Date: 17 September 2014
Our ref: 130284
Your ref: 14/01384/OUT

Planning consultation: Development comprising redevelopment to provide up to 2600 residential dwellings (Class C3), commercial floorspace (Class A1 - A5, B1 and B2), social and community facilities (Class D1), land to accommodate one energy centre, land to accommodate one new primary school (Up to 2FE) (Class D1) and land to accommodate the extension of the primary school permitted pursuant to application (reference 10/01780/HYBRID). Such development to include provision of strategic landscape, provision of new vehicular, cycle and pedestrian access routes, infrastructure, ancillary engineering and other operations

Location: Bicester Eco Town Exemplar Site Banbury Road B4100 Caversfield

Proposed SW Drainage Strategy

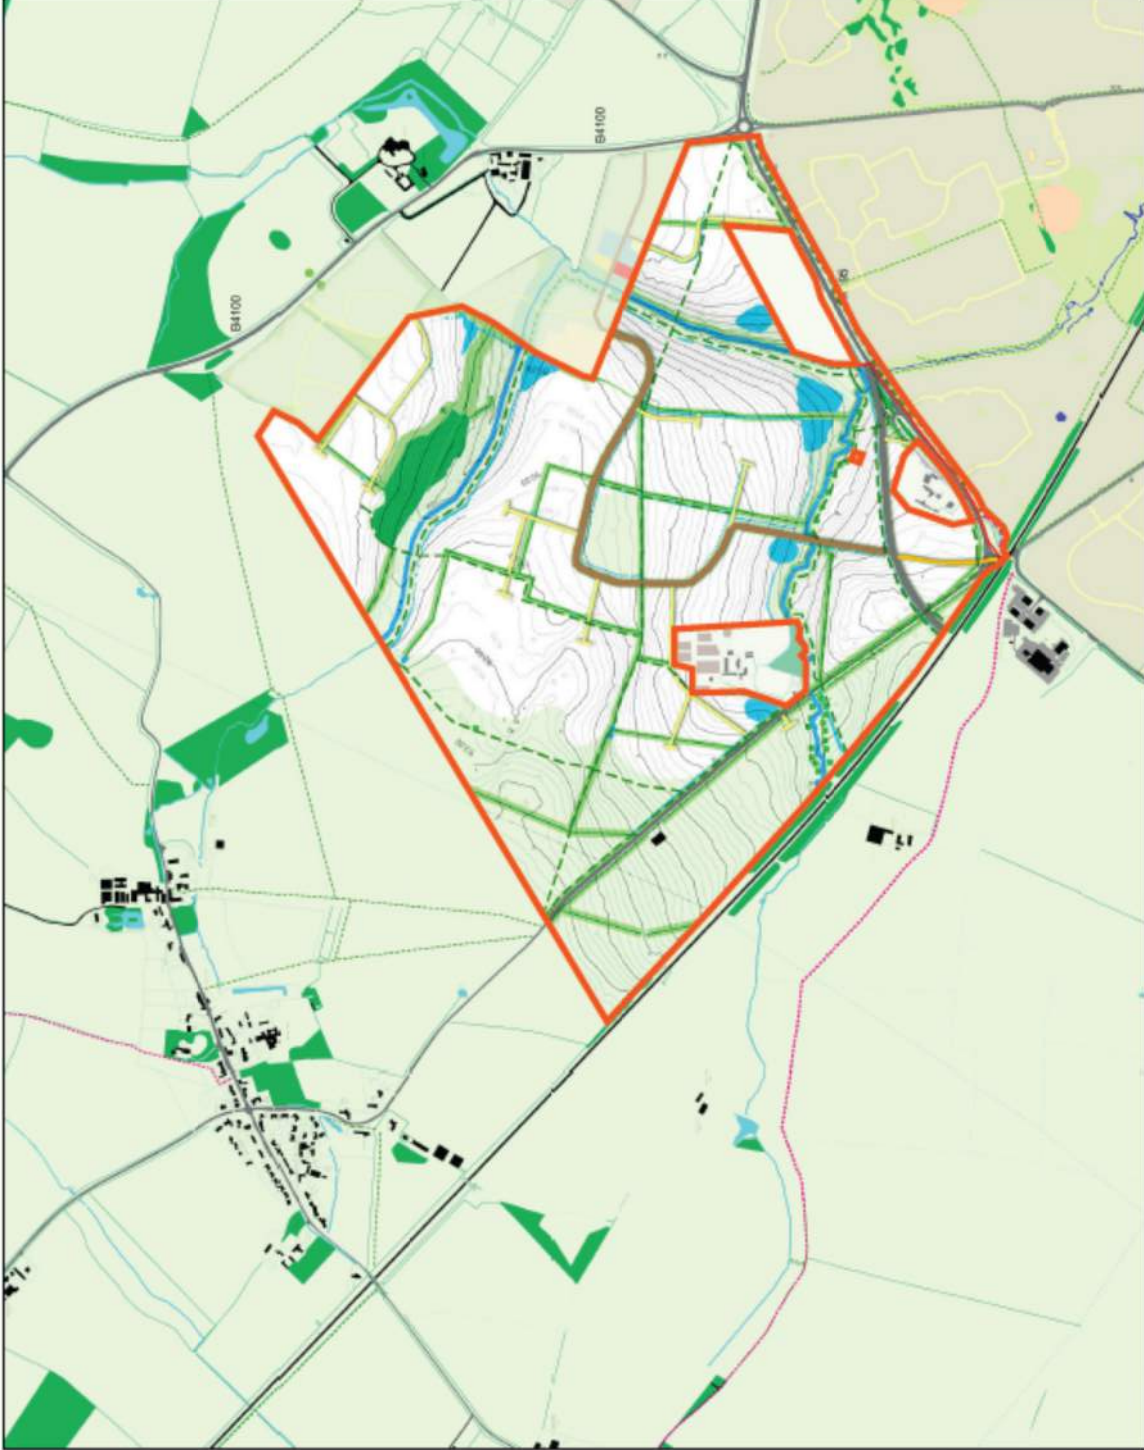
Details of SuDS and the Drainage Strategy from the Flood Risk Assessment to be adhered to in full, and constructed prior to other construction works on the site taking place, in order to protect downstream SSSIs.
